February 11, 2010

RE: 339 Woodford Street – 122-F-011 – R-5 Residential Zone – permit #10-0123

FUTURE FLOOR PLAN (1st Floor) REAR OF THE HOUSE FINISHED 16'

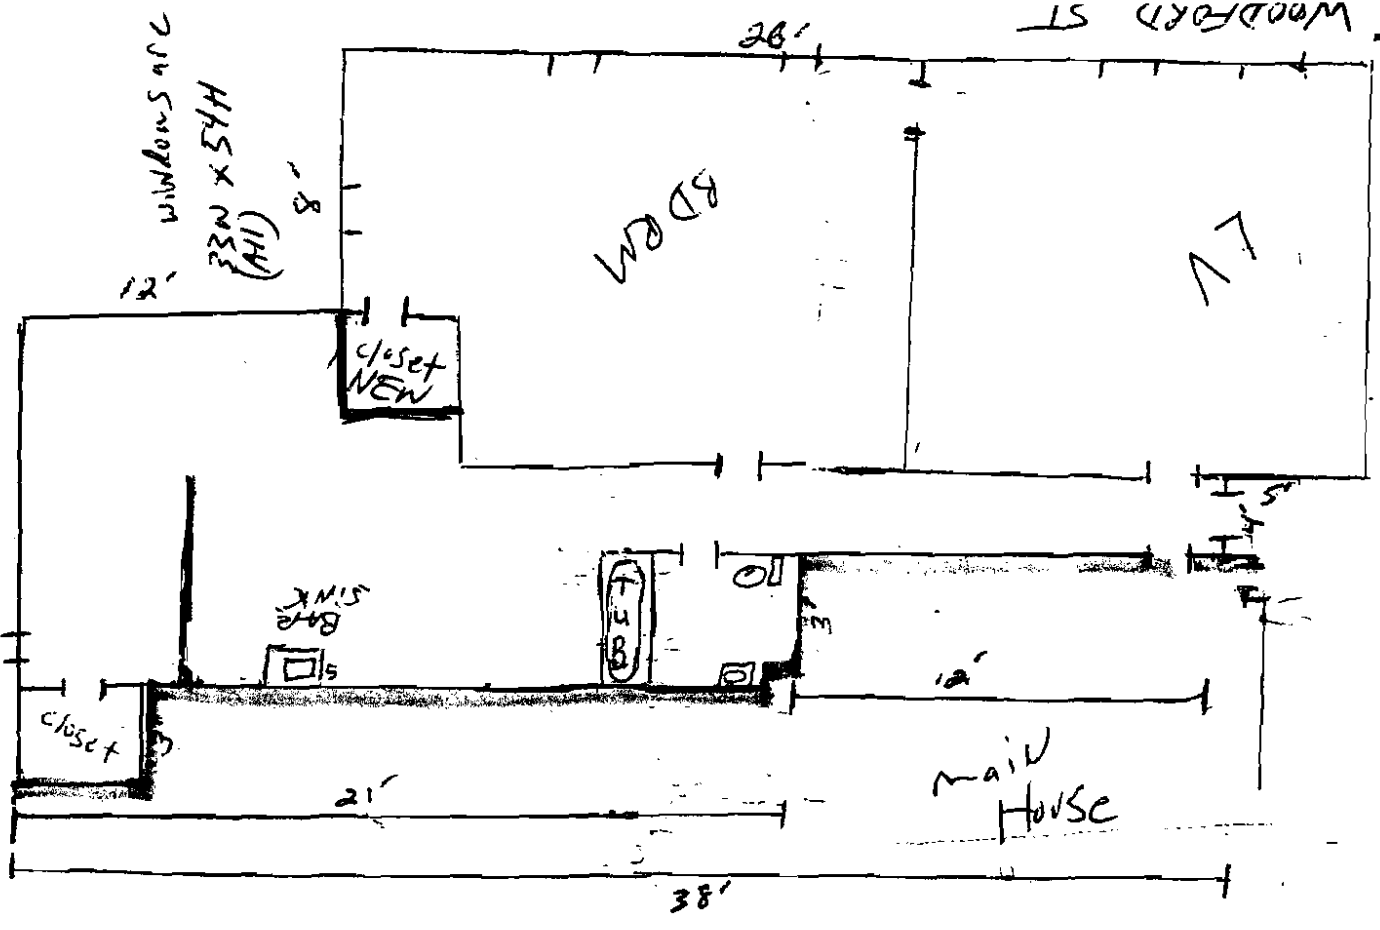
I am in receipt of your permit application to do work in your building at 339 Woodford Street in an area that was used as doctor's offices by a previous owner. When I spoke with you at the counter yesterday, you were going to create a new dwelling unit for a total of two dwelling units in your building. I understand that after you spoke with Jeanie Bourke discussing the Building Code requirements, you revised your application to create only be a bedroom suite and not a separate dwelling unit. However, per your application, there is already a separate kitchen in this area. If this is not going to be a separate dwelling unit now, you must remove the existing kitchen facilities. Kitchen facilities are what constitute a separate dwelling unit. Kitchen facilities are defined within the Land Use Zoning Ordinance as "Facilities used for the preparation of meals, including refrigerators and devices used for the cooking and preparation of food." We would need to inspect that all the kitchen facilities have been removed before we can move forward on this permit. I am also seeing that you will be removing the kitchen sink and replacing it with a bar sink. Before I can approve that change, I will need to see the specifications of the replacement bar sink. Bar sinks are limited on size. They are not the same as kitchen sinks.
